September 22, 2021

Re: Sigma Chi Apartments

1815 Sigma Chi Road NE

Traffic Circulation Layout

REVISION DATE
DATE 09-22-2021
SHEET NUMBER AS-1.0

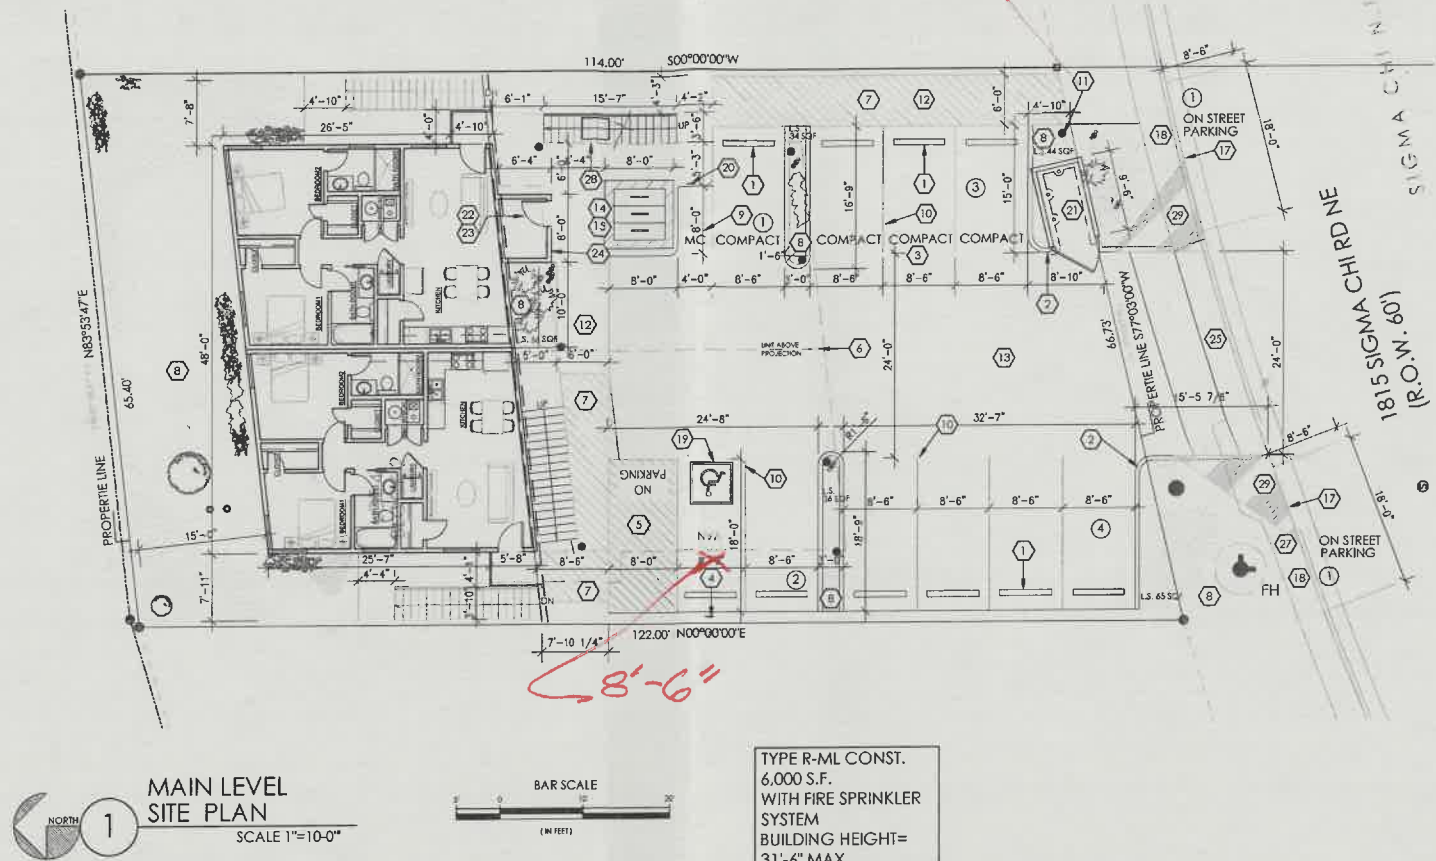
1. Listed are the number of parking spaces required by the IDO as well as the proposed number of parking spaces including bicycle and motorcycle parking. Coordinate/discuss with Zoning. **Status of Motorcycle Parkings(Explain)?**

2. Street name on Site Plan will need to be provided.

3. In accordance to AGIS, A sidewalk easement will be needed for sidewalk and curb & gutter located on private property. Please address this concern of property line location on AGIS versus Site Plan. **Site has a 10' set back from existing curb.**

4. Driveway entrance will need to be ADA complians. A construction note to remove and replace driveway with new needs to be added to Keyed Notes and the new width provided.

5. Keyed Note 6: shown on drive aisle! What is going on? Explain
Projection of 2 dwelling units above parking, 9'-1" clearance.

6. Keyed Note 25: Explain this note because if you need a mini work order by Water Authority to can be done with a note added.

7. Site Plan: shown on plan are 3 bumper symbols on parking stall. Please address.
Erased from site plan.

8. Identify the street width and ROW width on Sigma Chi Road.

9. The minimum parking stall dimensions are: **Motorcycle parking added on site plan**

10. The ADA accessible spaces must include an access aisle. Van accessible aisles should be 8ft wide (you have provided only 7'-8"); all others should be 5ft wide.

11. **Motorcycle parking spaces (Status?)** shall be designated by its own conspicuously posted upright sign, either free-standing or wall mounted per the zoning code. Label **pavement MC**.

12. Per the IDO, a 6 ft. wide ADA accessible pedestrian pathway is required from the public sidewalk to the building entrances. Please clearly show this pathway and provide details.

13. Per DPM, a 6 ft. wide ADA accessible pedestrian pathway is required from the ADA parking stall access aisles to the building entrances. Please clearly show this pathway and provide details.

14. **Curbing should be installed to delineate landscape, parking, and pedestrian ways and identify points of access. Please call out detail and location of barrier curb.**

16. Add a note stating "All broken or cracked sidewalk must be replaced with sidewalk and curb & gutter." A build note must be provided referring to the appropriate City Standard drawing (2430 & 2415A).

Added to Site plan

Added to site plan 1815 SIGMA CHI RD NE

COA STD DWG 2525A (drivepad detail) is acceptable since it demonstrates ADA compliance across the drive pad entrance.

Note removed, if it's necessary, a mini work order for any water/sewer it can be obtained from Water Authority.

30' wide and 60' R.O.W. added to plan

Fixed on site plan

Motorcycle parking spaces added on site plan and sign noted and shown on plan.

Path shown with hatch on plan.

Path shown with hatch on plan.

In the area, parking and sidewalks are at the same ground level of public sidewalks, curbs will be only required for landscaping areas.

This guideline already on the plan. General note number 1.
